Design and Access Statement
August 2022

1 Warwick Road,
West Drayton

1 Proposed 3rd Floor Plan

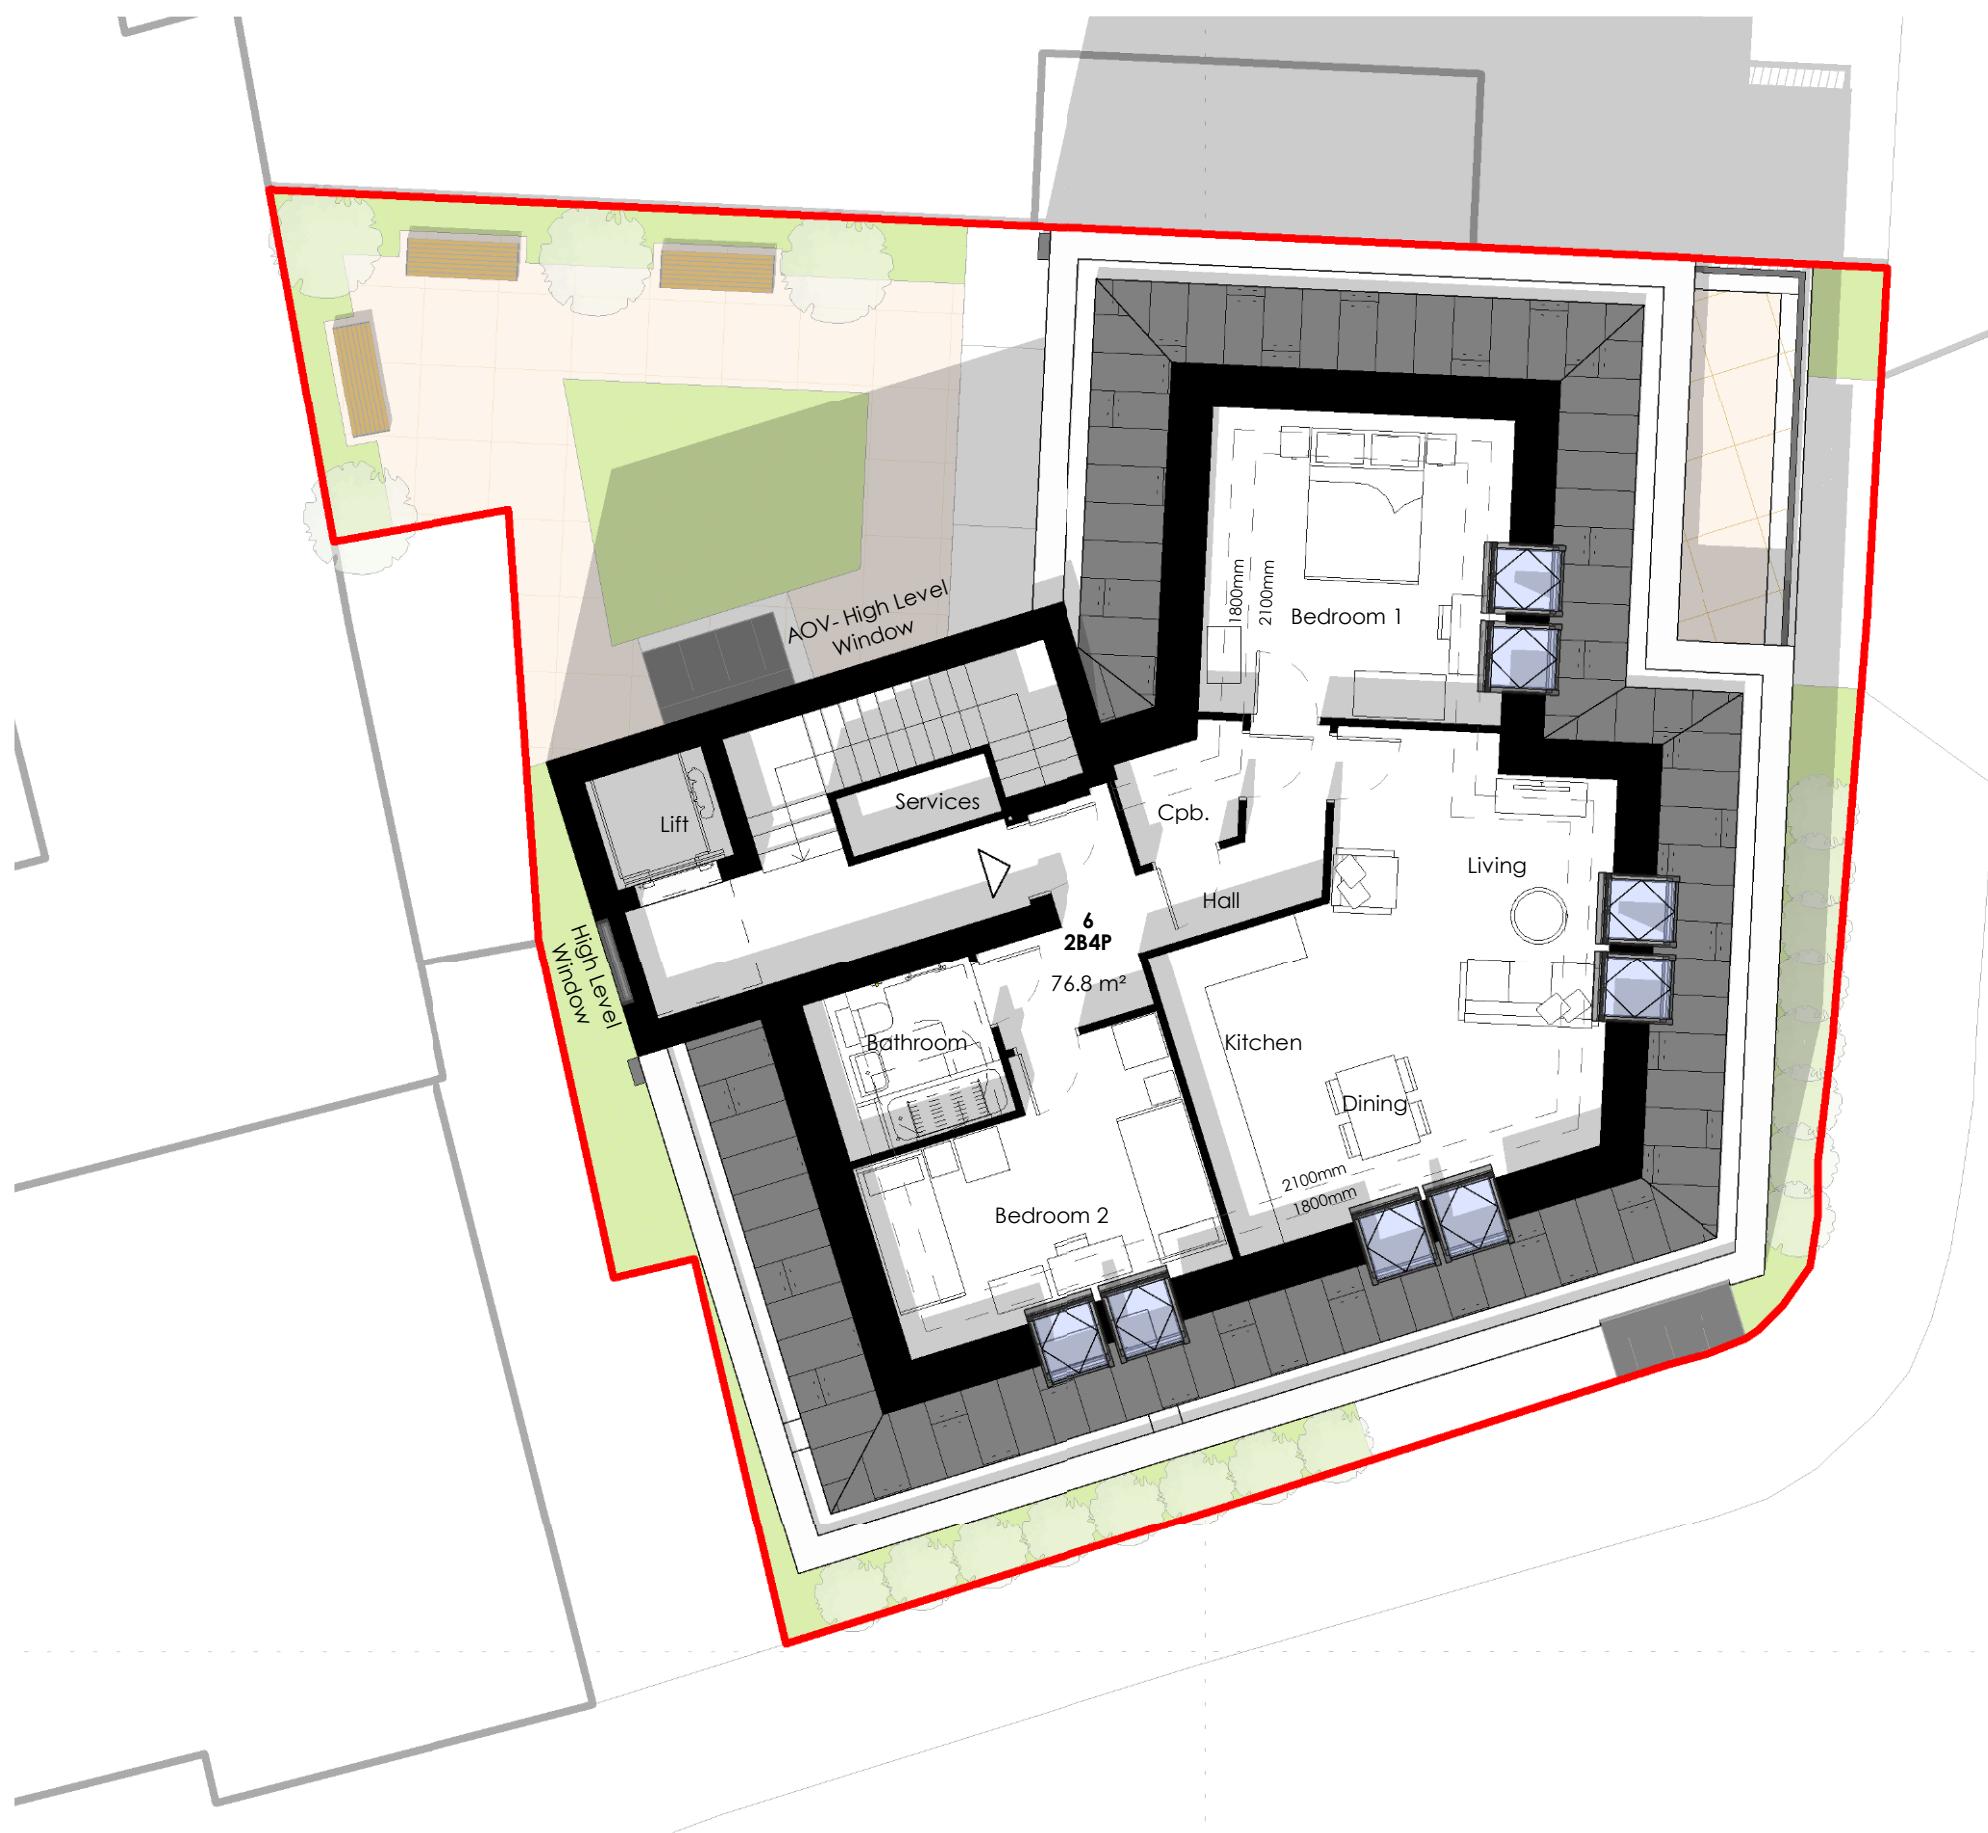
The pre-app letter appreciates the set back of the fourth storey, however the planning officer raises concerns that “*the views of the fourth floor would still be prominent particularly when traveling along Warwick road towards High Street*”.

To address this we have revisited the proposed North-East corner and the relation to the neighbouring property. The revised proposal introduces an additional set back on the second floor, which brings down the parapet height along Warwick Road.

3 Elevation 3
1 : 100

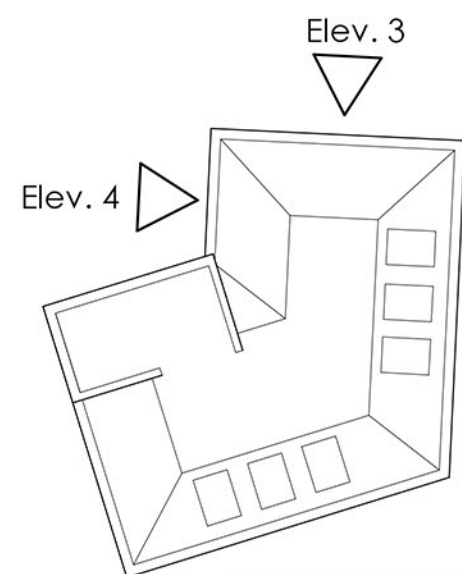
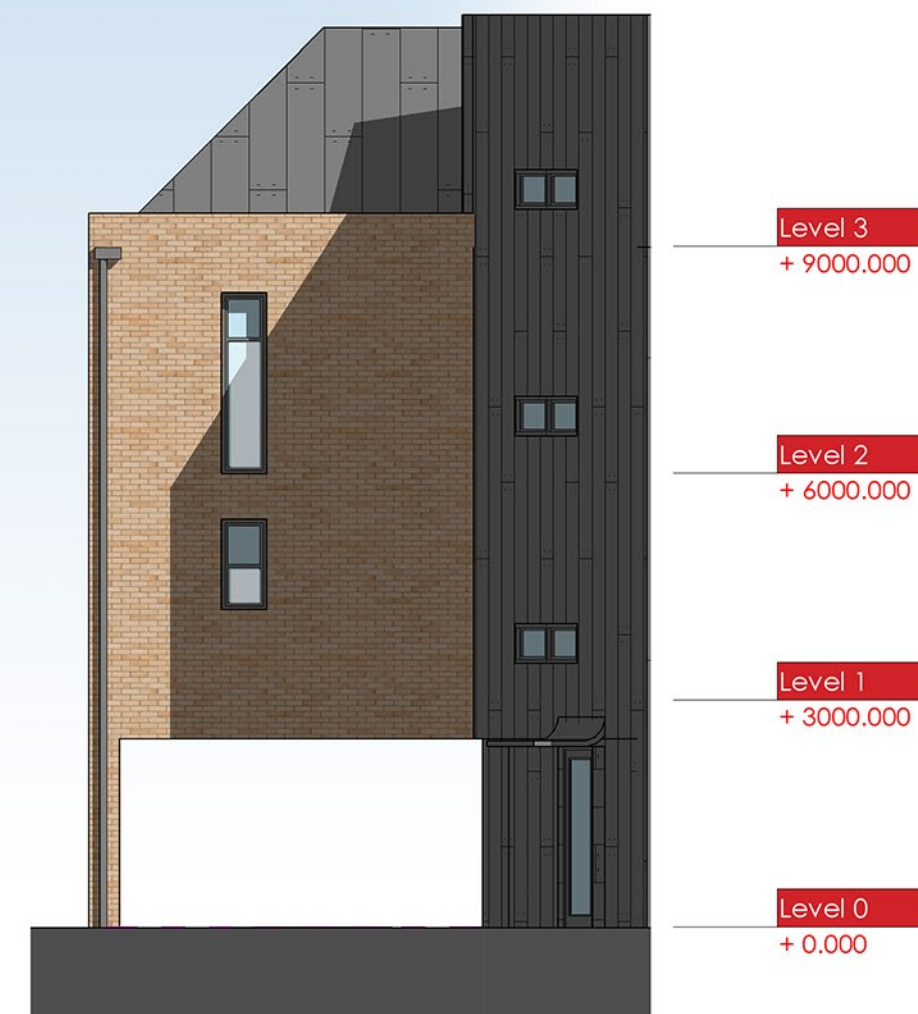
The pre-application response letter states that "the proposed plans should clearly demonstrate compliance with the minimum distance (e.n. 21m) (...) and so that the development would not result in adverse harm to neighbouring properties in terms of outlook and overshadowing".

- no habitable room or singular windows towards the rear or side of the proposals. The only rear and side windows serve either kitchens or communal areas and are high level windows
- all of the habitable rooms were positioned fronting Warwick Road
- where the proposed building comes slightly close to neighbouring buildings (south-east corner), bedrooms are proposed.
- the proposed living rooms areas are set back from the building lines, behind terraces.
